REQUEST

Current Zoning: N1-B (neighborhood 1-B)
Proposed Zoning: INST(CD) (institutional, conditional)

Approximately 5.10 acres located on the west side of Statesville Road, east of Milhaven Lane, and south of Sunset Road.

The petition proposes to develop a 15,000 square foot facility for special needs youth and adults on vacant land.

RZ-2.0

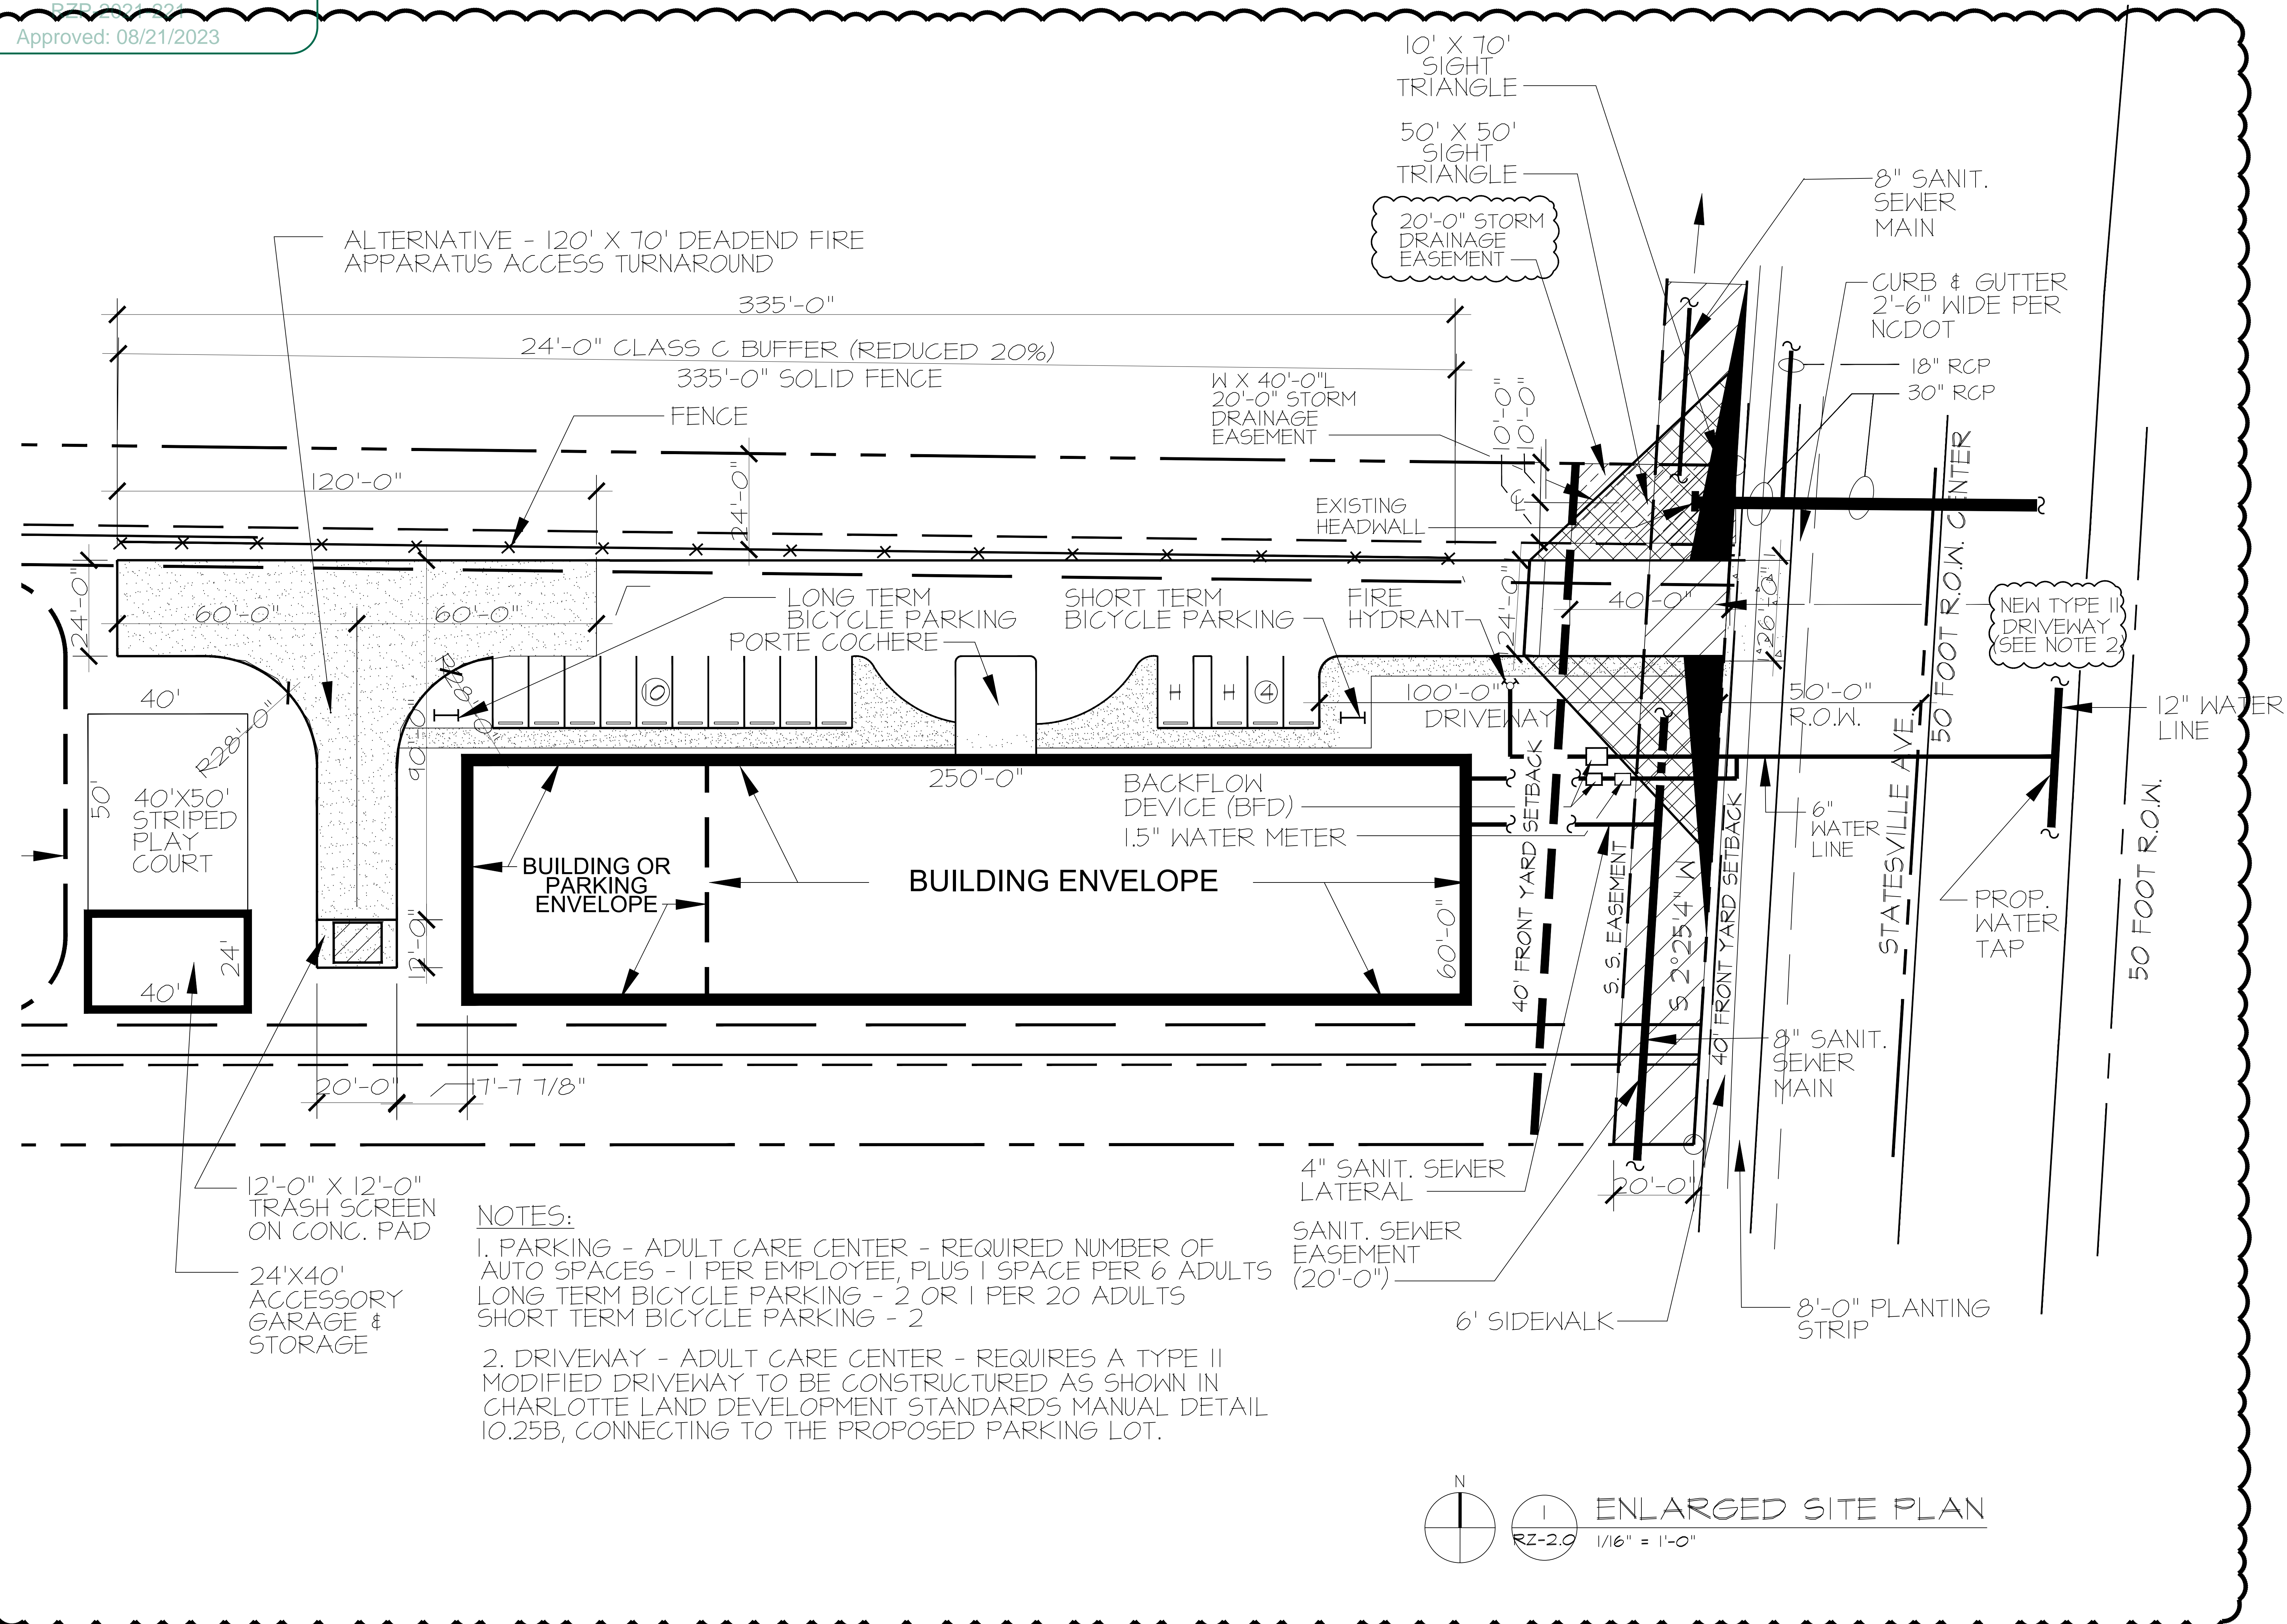
1. ~~Revise site plan and conditional note(s) to commit to construct a Type II Modified driveway as depicted in Charlotte Land Development Standards Manual detail 10-25E connecting to the proposed parking lot.~~ Addressed
